FIVE ESTUARIES OFFSHORE WIND FARM

10.40 APPLICANT'S COMMENTS ON DEADLINE 5 SUBMISSIONS

Application Reference:	EN010115
Document Number:	10.40
Revision:	A
Pursuant to:	Deadline 6
Eco-Doc Number:	005644359-01
Date:	February 2025

Title
**FIVE ESTUARIES WIND FARM
ONSHORE SUBSTATION
ELEVATIONS OF SUBSTATION
COMPOUND- AIS OPTION
Sheet 01 of 01**

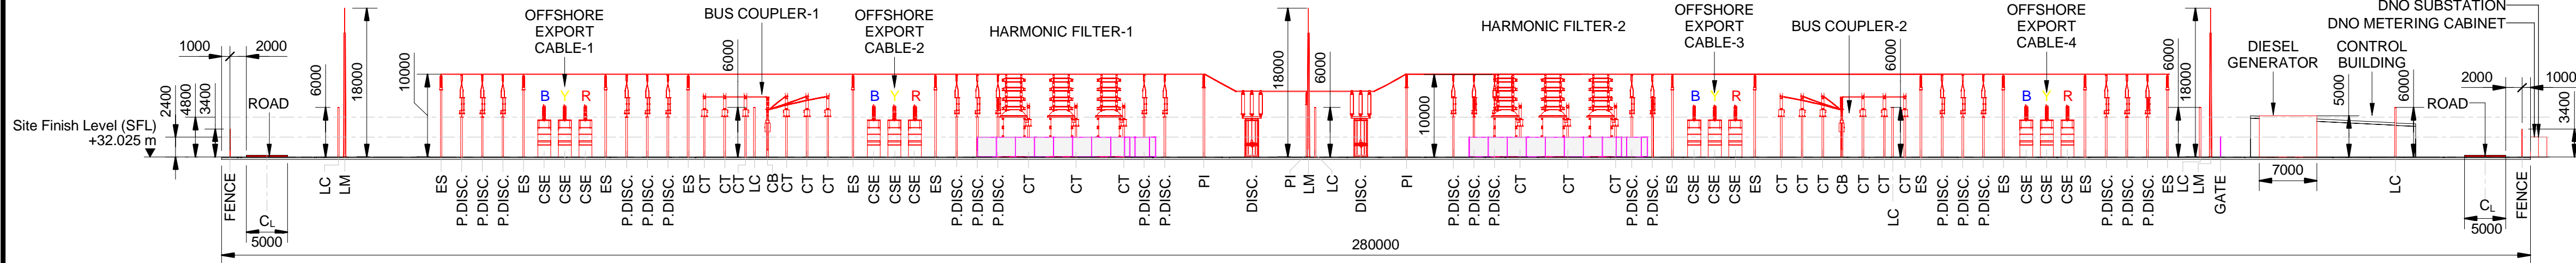
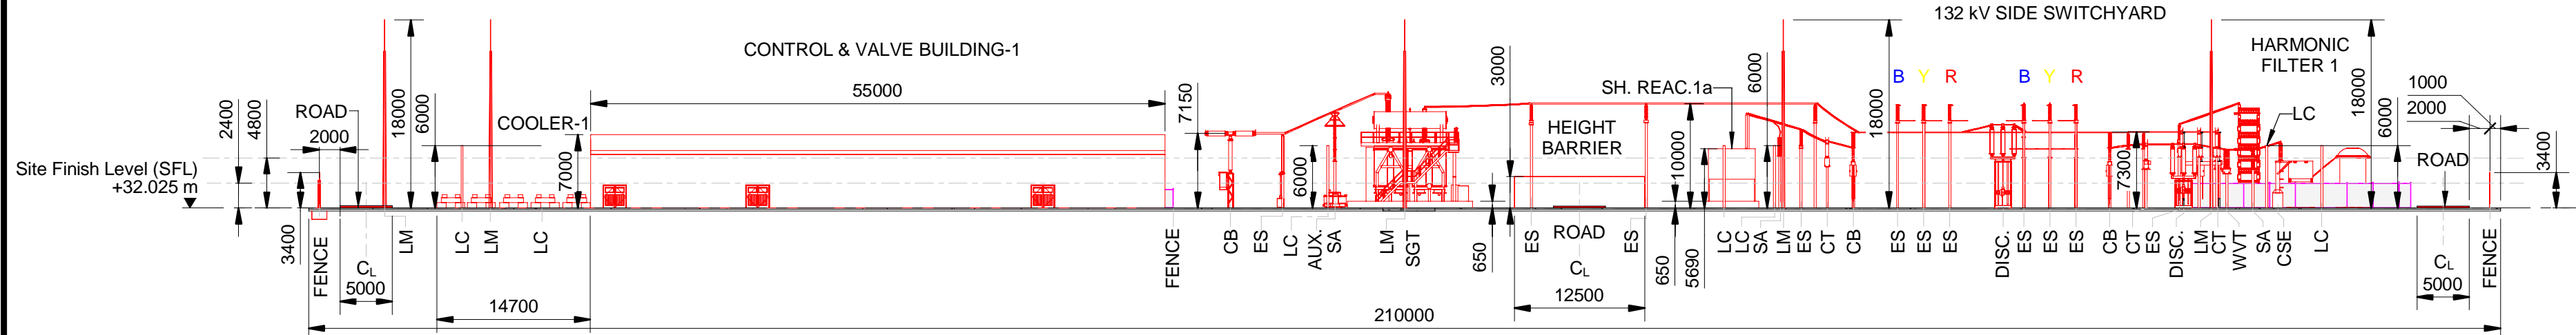
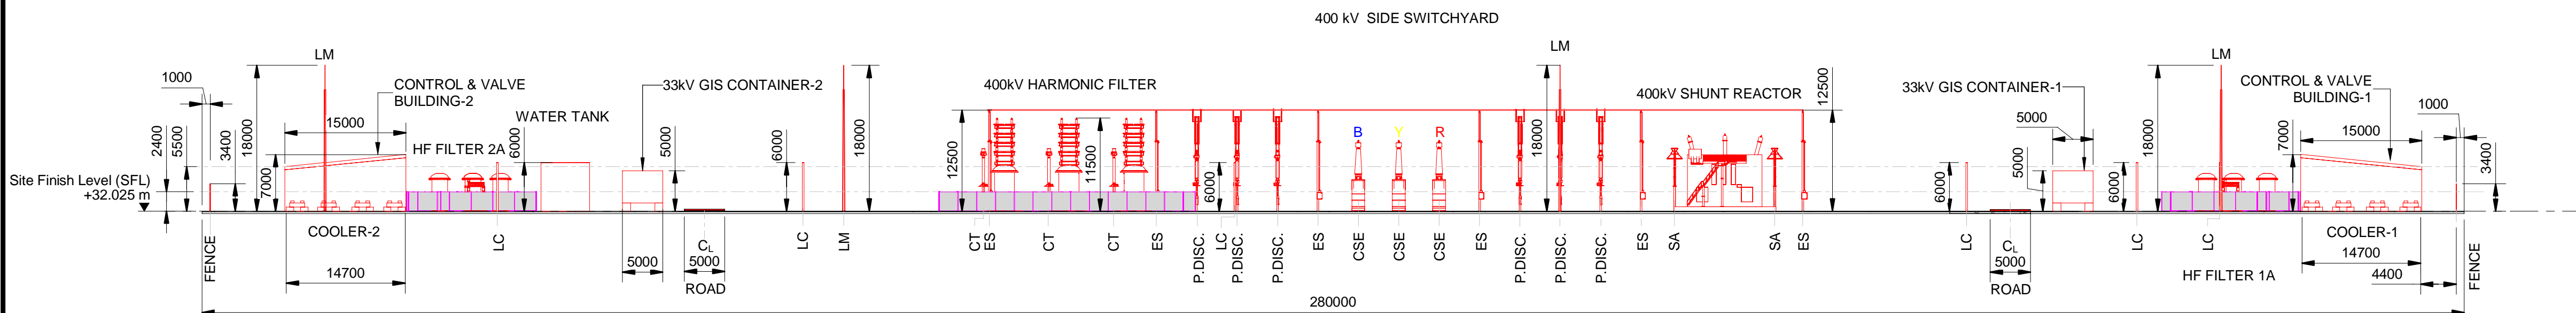
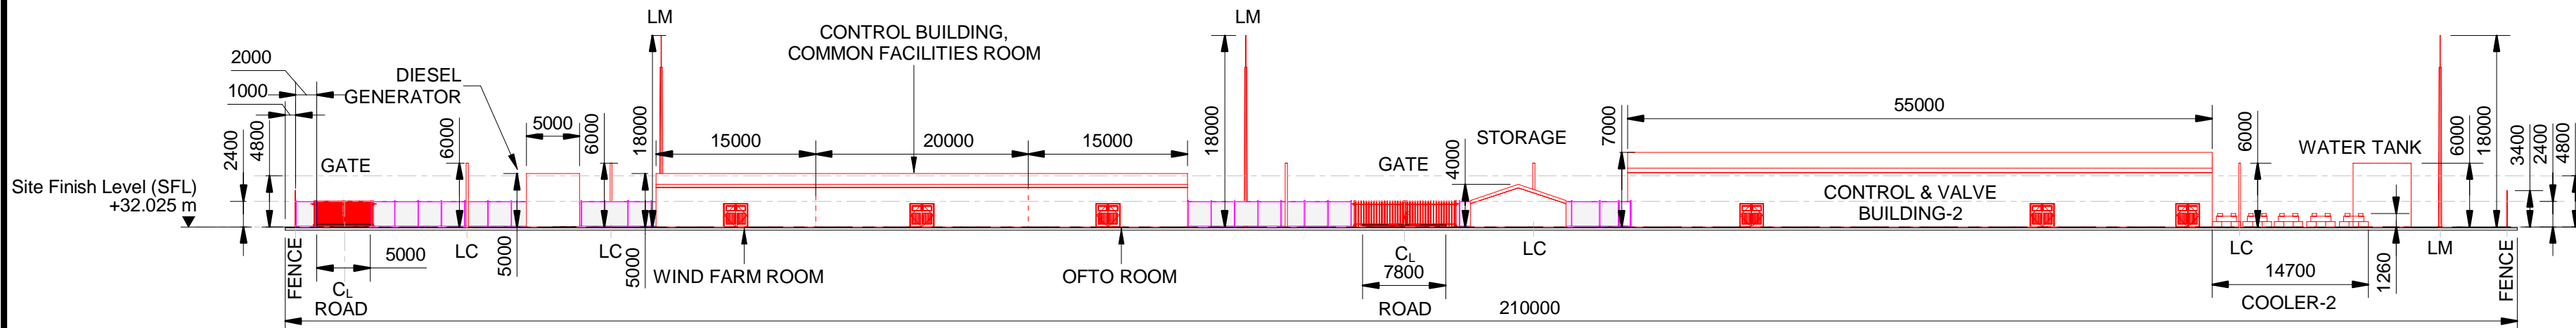
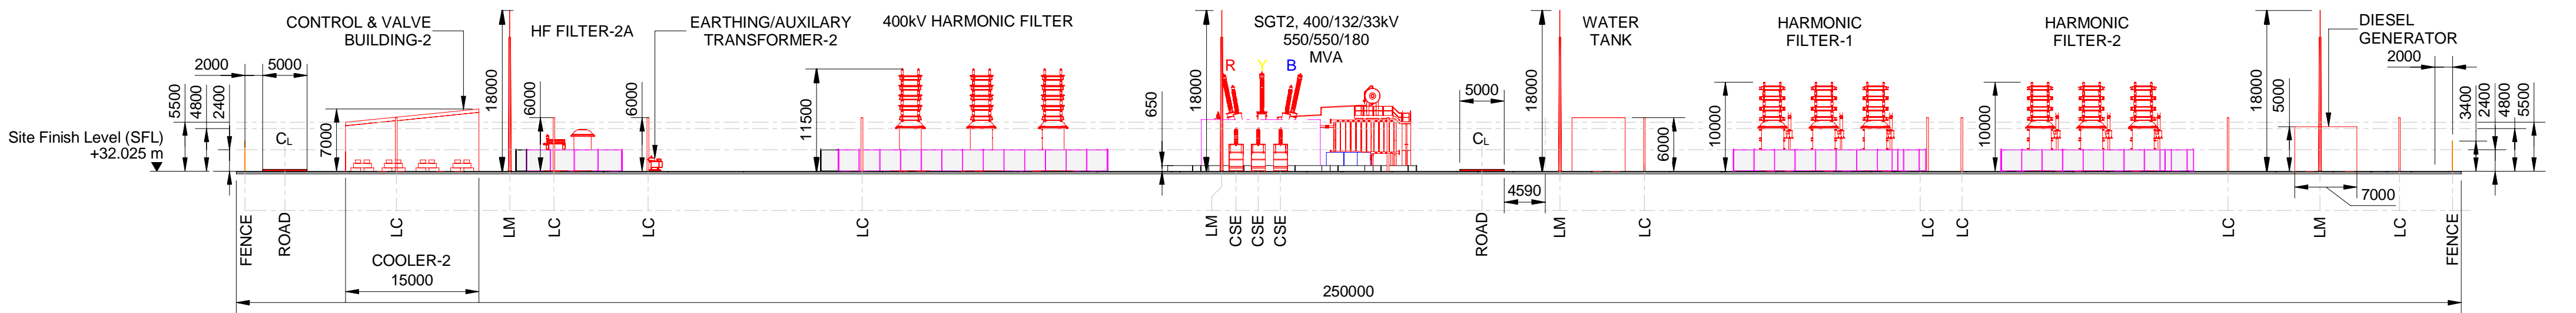
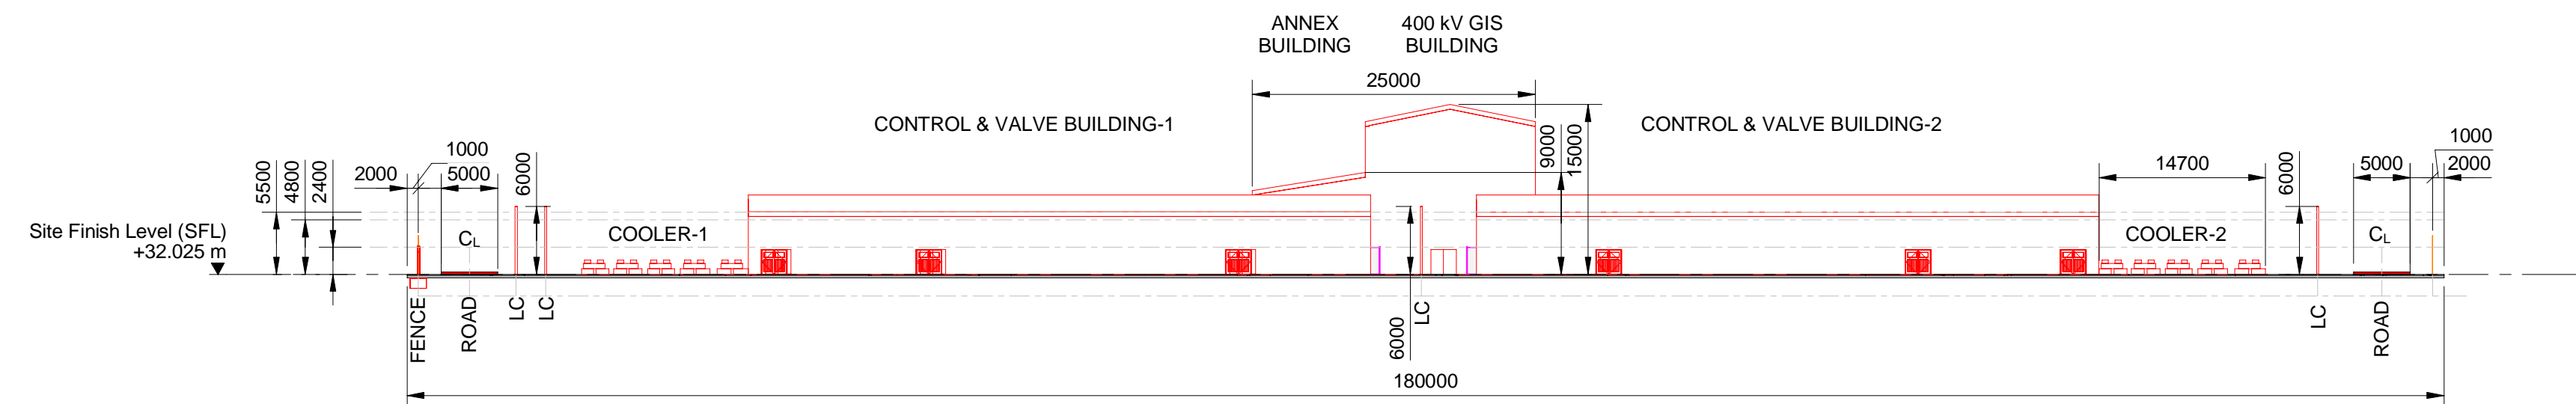
ECC-05	The Joint Councils note the applicant's submission at D04 with the reference REP4-038 which shows planting progression over time. However, this is not set against any of the as proposed substation elevations, which will be significant in scale and form for whichever option is implemented, hence the impact and suitability of the same is difficult to assess.	The Applicant has prepared three cross sections to show the relationship between visual receptors and how the mitigation planting would grow sufficiently to screen the onshore substation at years 5, 10 and 15. These have been included in 9.22 Outline Landscape and Ecological Management Plan – Revision D, submitted at Deadline 6. The cross sections illustrate the Five Estuaries onshore substation using the GIS model (comprising larger buildings compared to the AIS model) to cover the worst-case scenario. The optionality to select either GIS or AIS as the preferred technology is retained by the Project.
